Submissions Report (MOD-3)

State Significant Development (MP07_0048-MOD-3)

Enviroking Liquid Waste Facility Project

843 John Renshaw Drive, Black Hill

1 > PROPOSED INTERNAL LAYOUT 1:200

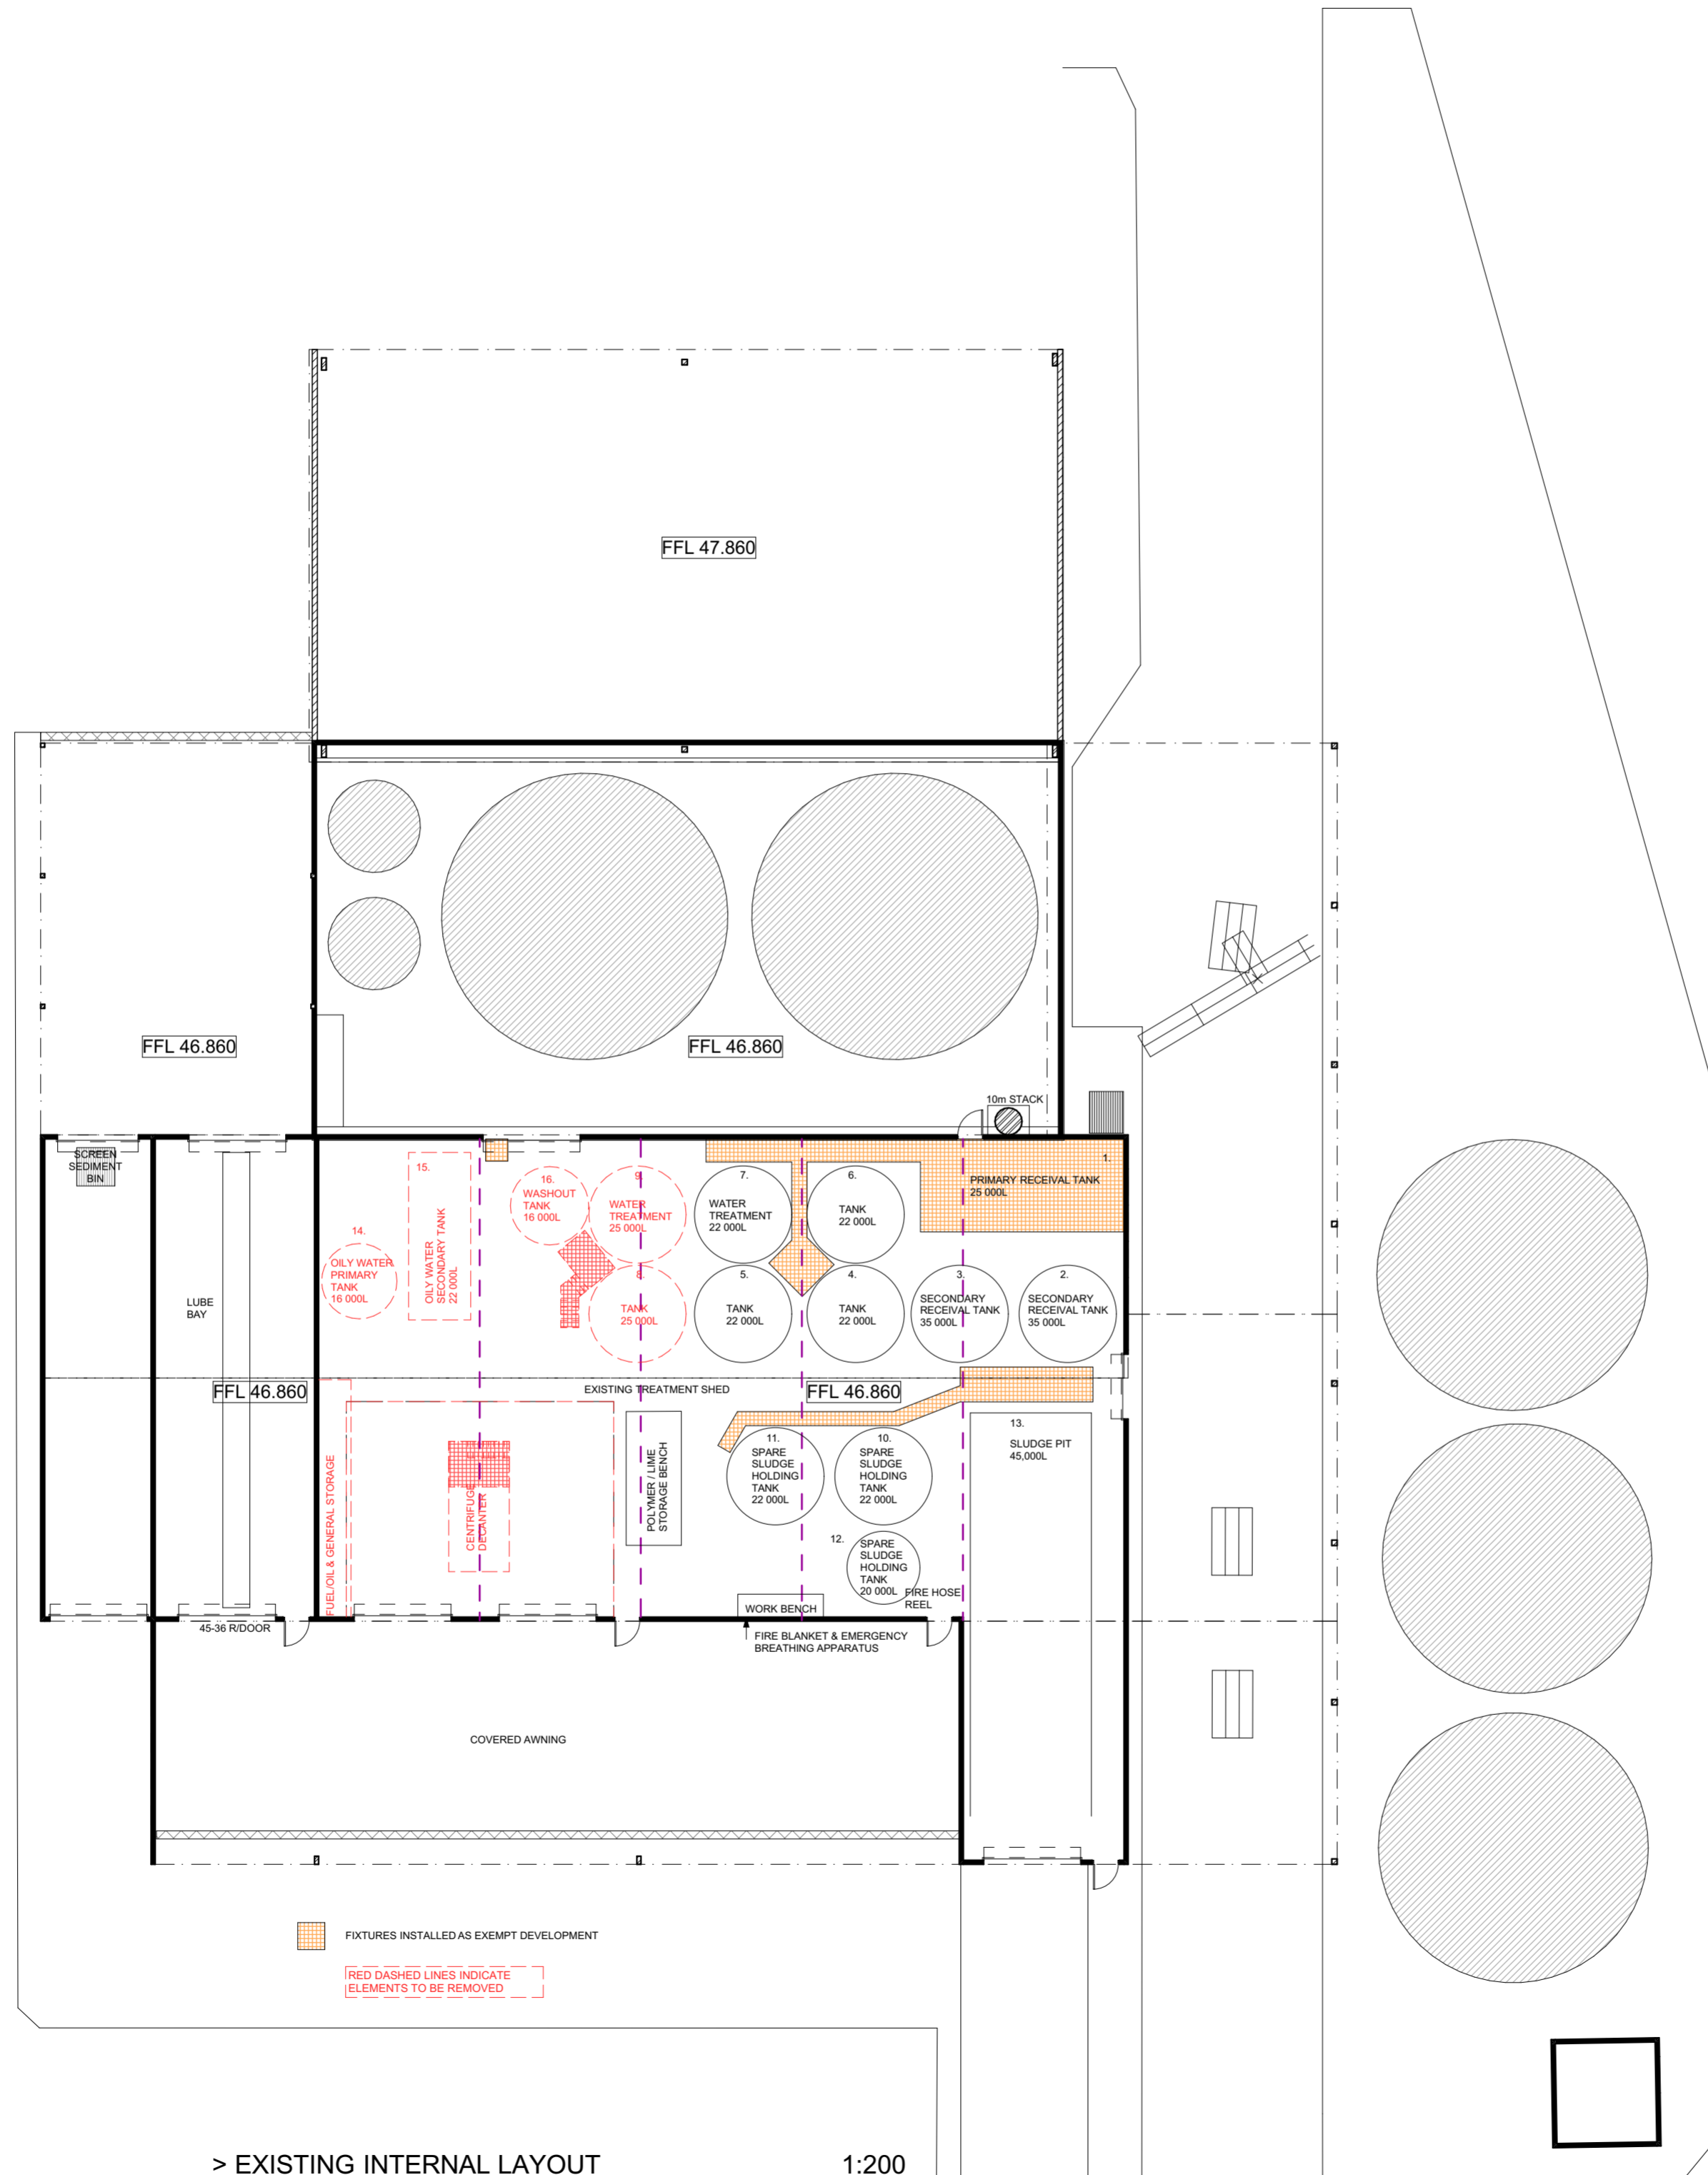
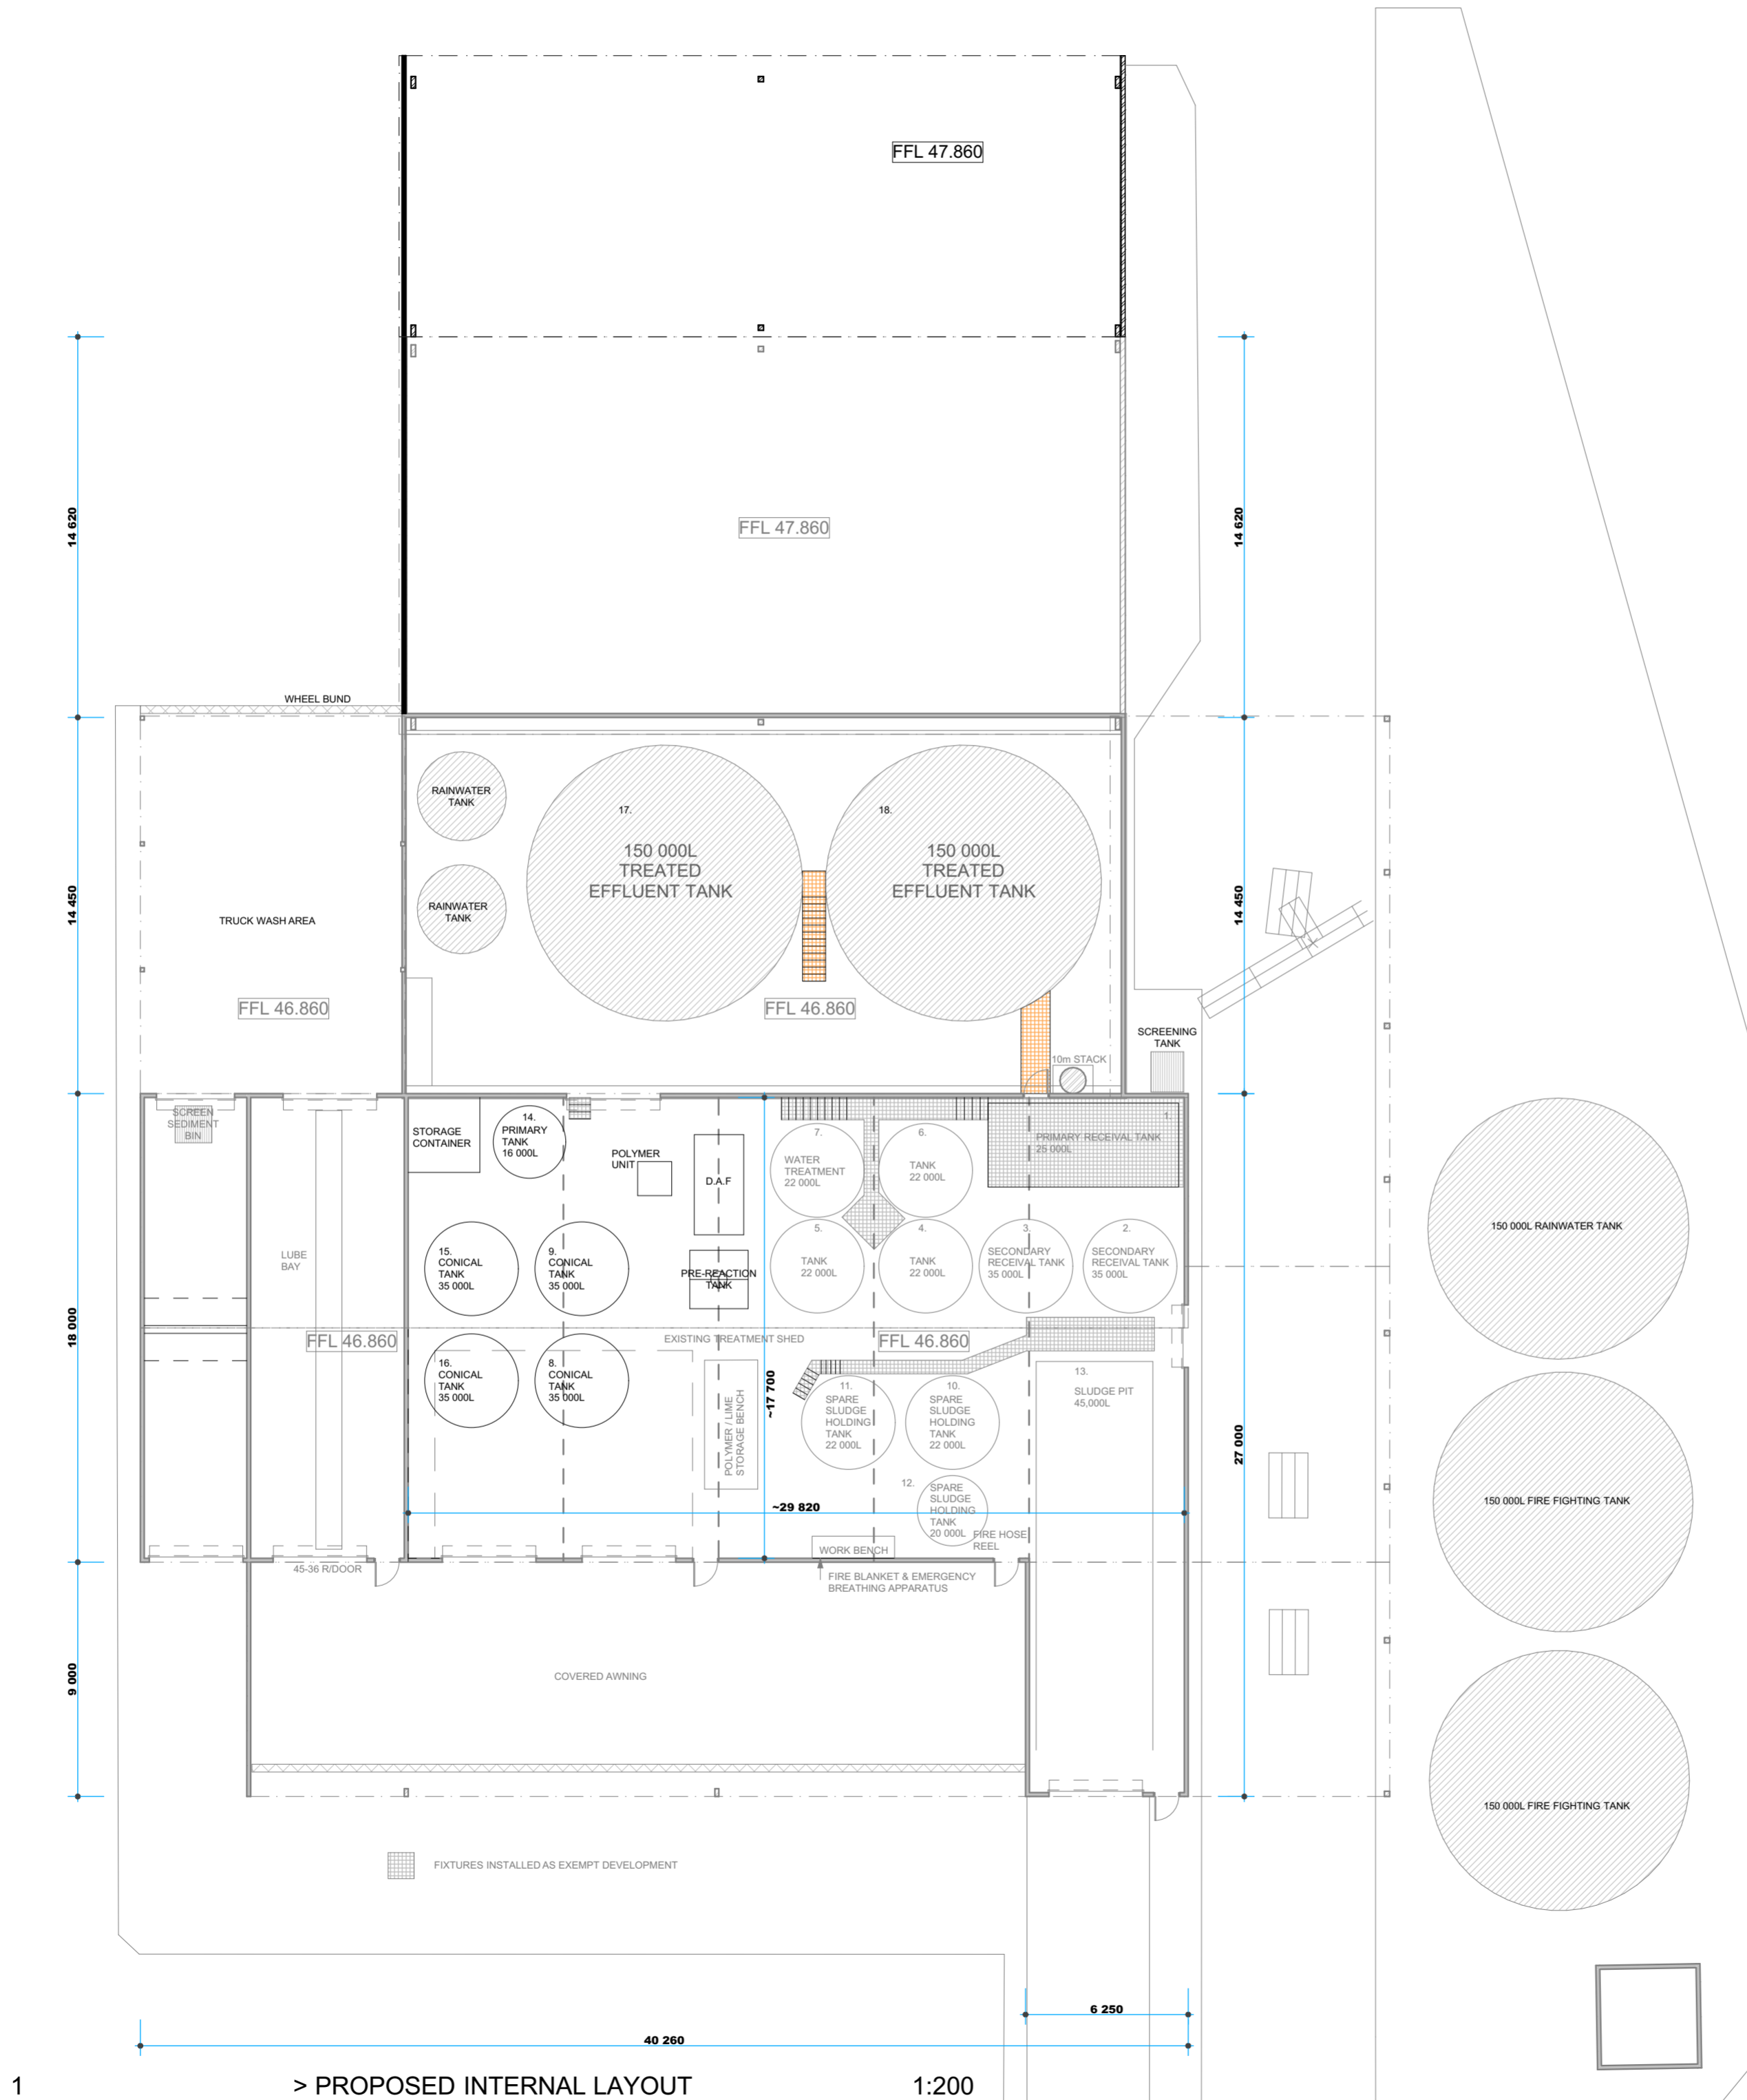
Item #	Issue	Response	Reference
8.1	<p>1. Treated effluent from the Facility represents a high risk to the operation of Hunter Water's Wastewater Treatment Works (WWTW), and in particular Hunter Water compliance with our Environment Protection Authority (EPA) Environment Protection Licence (EPL).</p> <p>2. Hunter Water therefore conducts sampling and testing of effluent at the Facility, and this testing has shown continual non-compliance with Hunter Water's Trade Waste acceptance levels.</p> <p>3. Hunter Water has observed a correlation between tankered effluent from the Facility and a negative impact on the biological processes at receiving WWTWs, and in particular reduction of dissolved oxygen. This in turn impacts effluent quality discharged from our WWTWs with the potential to result in a breach of Hunter Water's EPL or cause an environmental incident under the POEO Act.</p> <p>4. The Proponent will need to revise the annual tankering agreement with Hunter Water as a result of the Project.</p> <p>5. Pre-treatment of the effluent tankered to Hunter Water WWTWs is not identified in the Modification Report.</p> <p>6. In order to ensure treated effluent quality received at Hunter Water's WWTWs remain within Trade Waste specification, it will be necessary for the Proponent to include upgraded pre-treatment processes as part of the Project.</p>	<p>The existing wastewater pre-treatment process was detailed in Section 3.3 of the Modification Report.</p> <p>Notwithstanding, the proposal has been amended to install a DAF unit to treat wastewater to a higher standard than the existing approved process.</p> <p>The DAF unit generates microbubbles via a recycle stream saturated with air under pressure. The microbubbles attach to suspended solids, oils, and grease which then float to the surface and are scraped off by a mechanical scraper and the sludge is directed into an integrated hopper, before being pumped out to a sludge storage tank.</p> <p>To accommodate the DAF Unit, changes to the internal layout of the treatment shed are required. Key modifications to the layout are summarised as follows:</p> <ul style="list-style-type: none"> • Removal of the existing centrifuge (to be stored, scrapped or sold); • Replacement and relocation of Tanks 8 and 9 (increased in size from 25,000L to 35,000L conical tanks) for use as Post-DAF treated water storage prior to off-site disposal; • Relocation of existing Tank 14 to the rear of the shed to continue to be used for oily water storage; • Replacement and relocation of Tank 15 (increased in size from 22,000L to 35,000L conical tank) for use as Post-DAF treated water storage prior to off-site disposal; • Replacement and relocation of Tank 16 (increased in size from 16,000L to 35,000L conical tanks) for use as Post-DAF treated water storage prior to off-site disposal; • Installation of the DAF unit, pre-reaction tank and polymer unit at the rear of the shed proximate to the existing power board. <p>The modified treatment process is as specified below:</p>	<p>Amendment Report (Mod 3) – Section 2.4 and 2.5</p>

In response to HWC's concerns relating to the quality of wastewater disposed of at HWC STPs, the proponent has amended the proposal to undertake internal alterations to the existing wastewater treatment shed.

These alterations consist of removal of redundant equipment and storage tanks, the installation of a Dissolved Air Flotation (DAF) unit for additional treatment of wastewater and the installation of new storage tanks and chemical storage areas to accommodate the improved treatment process. These works are also detailed in the Amendment Report.
